PALERANG COUNCIL

1 February 2011

**Re: Review of Proponent Response
Dargues Reef Gold Project, Major Project Application No. 10_0054**

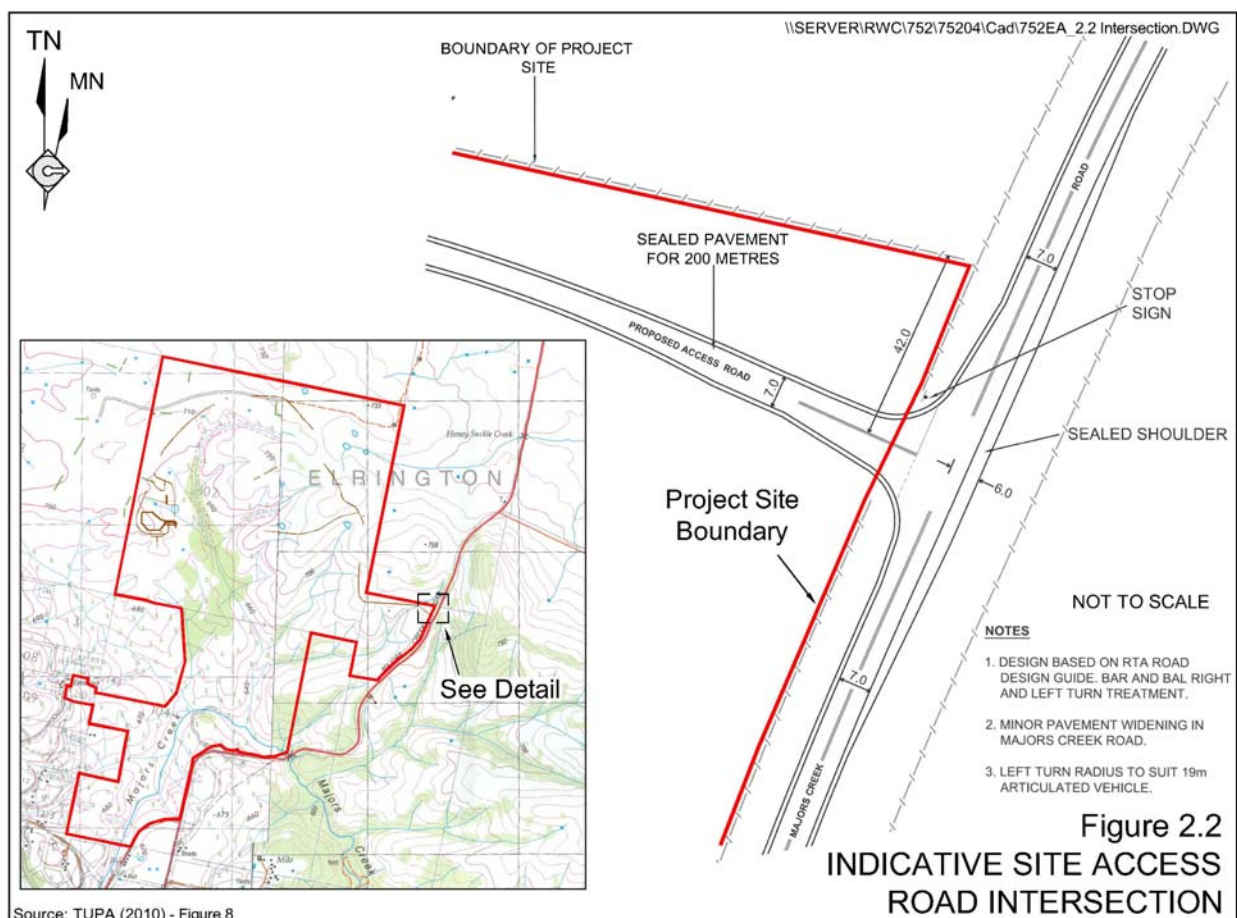
The applicant has proposed an entrance point to the mine off Majors Creek Road approximately 9.3 km south of Araluen Rd. While the sight distances at this location appear to be adequate for the design speed of the road, the applicant's proposal to provide only a BAR/BAL standard treatment is in conflict with recommendations made by the Local Traffic Committee. Considering the area that potential employees may be sourced from, Council does not believe that the statement that a bus will transport the majority of employees, adequately reflects what the traffic movements will actually be. Individual staff vehicle trips need to be

Council, with advice from the Local Traffic Committee, has recommended that draft conditions of approval include provision of:

- a. AUR/AUL treatment at the entrance intersection
- b. Acceleration lane from the intersection uphill towards Braidwood

It is considered that these are the appropriate treatments at this location on a 6% longitudinal grade where significant numbers of heavy vehicles associated with the mine's operation will

- decelerate, prop and then turn right on entering the site on the downhill grade, and
- turn out of the entrance to the left and need to accelerate when laden on the uphill grade towards Braidwood.

These stop/start and slow movements of these trucks at this location will come into conflict with passing traffic on Majors Creek Road. Adequate pavement area, provided by the above treatments, will ensure sufficient space for safe manoeuvring for all vehicles, reduce delays for vehicles on Majors Creek Road and at the same time protect Council's road asset which will suffer edge and shoulder failure under the lesser treatments suggested by the consultant for the applicant.

There will many vehicles passing on the outside of the right turning trucks, causing damage to the bitumen edges and the need for regular shoulder maintenance of the BAR treatment. The RTA 's Road Design Guide at subsection 4.5.2.1 suggests 'that a layout with auxiliary lanes may be more appropriate[than a BAR treatment] when shoulder wear is a problem [ie adopt an AUR treatment]. Likewise the slow laden trucks leaving the site uphill will tend to keep over to the left thus causing serious damage to shoulder areas if no acceleration lane is provided.

3. The following treatments be constructed by the applicant at the site of the entrance from Majors Creek Road, in accordance with RTA's Road Design Guide:

- a) Intersection in accordance with RTA's AUR/BAL standard treatment
- b) Acceleration lane on Majors Creek Road on the up-grade towards Braidwood.
